EAGLEVIEW REGIONAL DRAINAGE IMPROVEMENTS GRADING AND EROSION CONTROL PLAN

EPC STORMWATER REVIEW COMMENTS
IN ORANGE BOXES WITH BLACK TEXT

EAGLEVIEW REGIONAL DRAINAGE IMPROVEMENTS
EL PASO COUNTY, COLORADO
GRADING AND EROSION CONTROL PLAN
GESC COVER SHEET

PROJECT NO. 196106001
SHEET 3

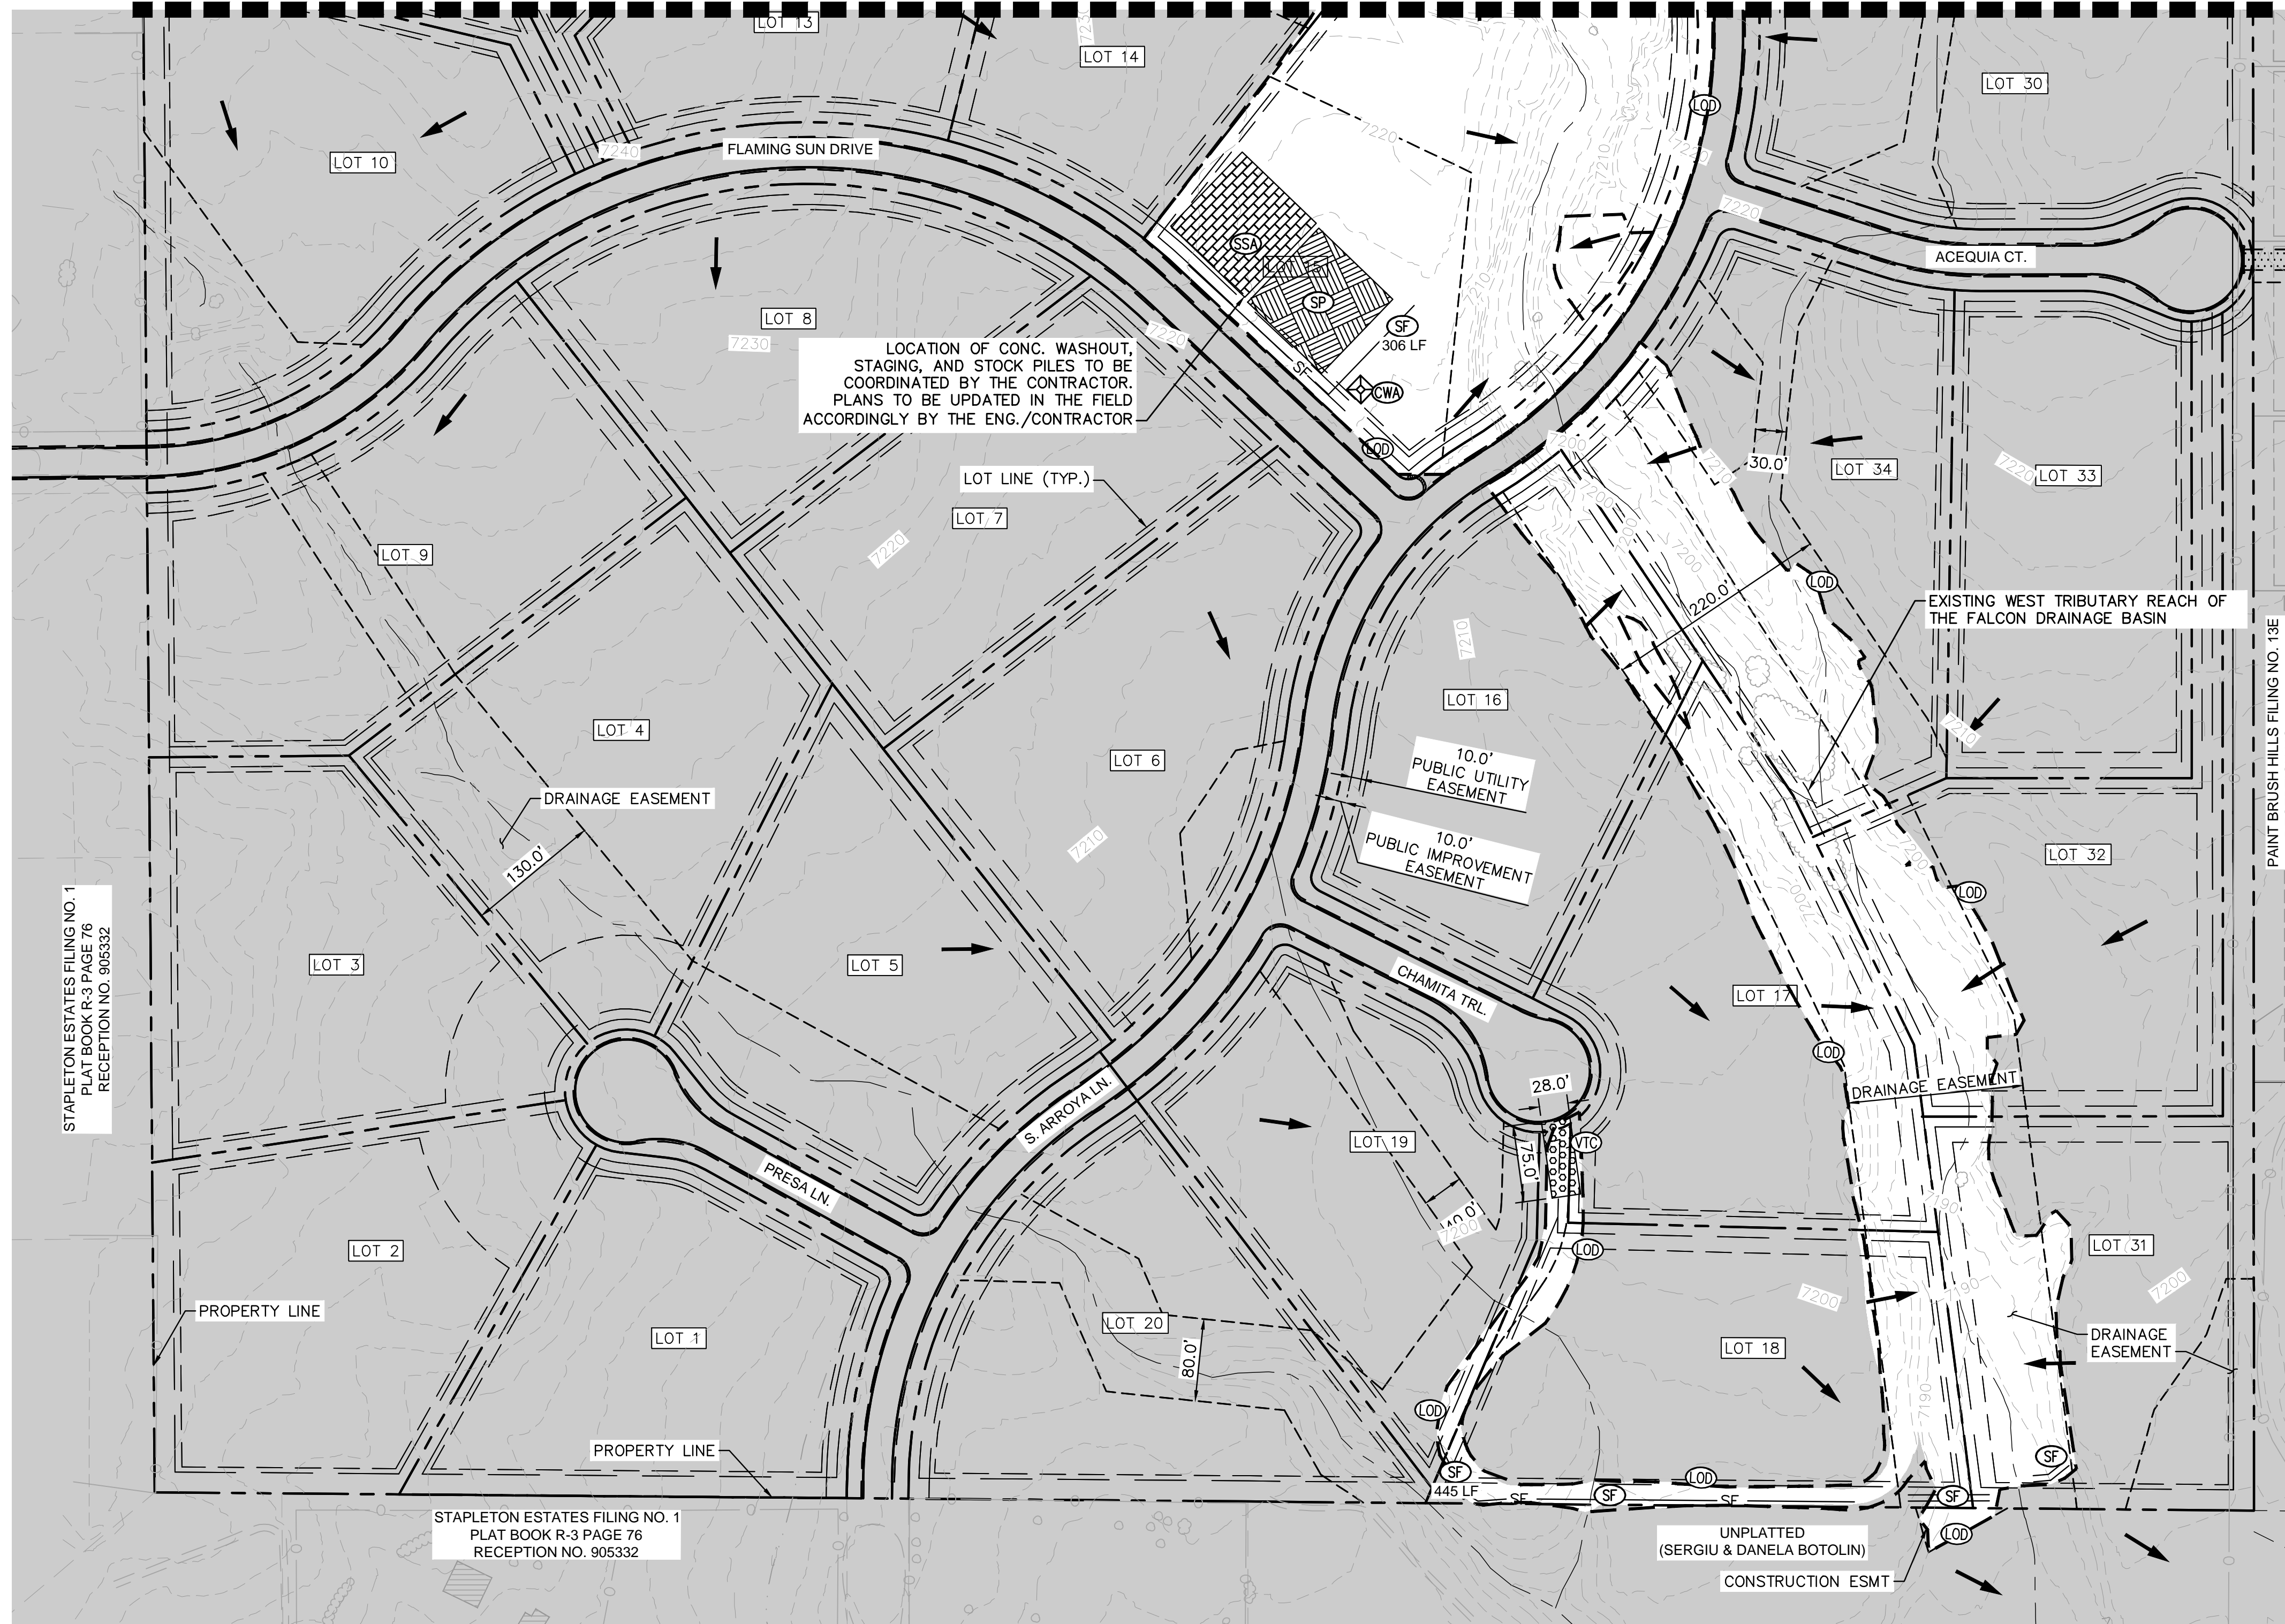
SP and pattern are not in the legend. Is this supposed to be soil stockpile? Update to match legend if so.

Provide geotechnical report for review.
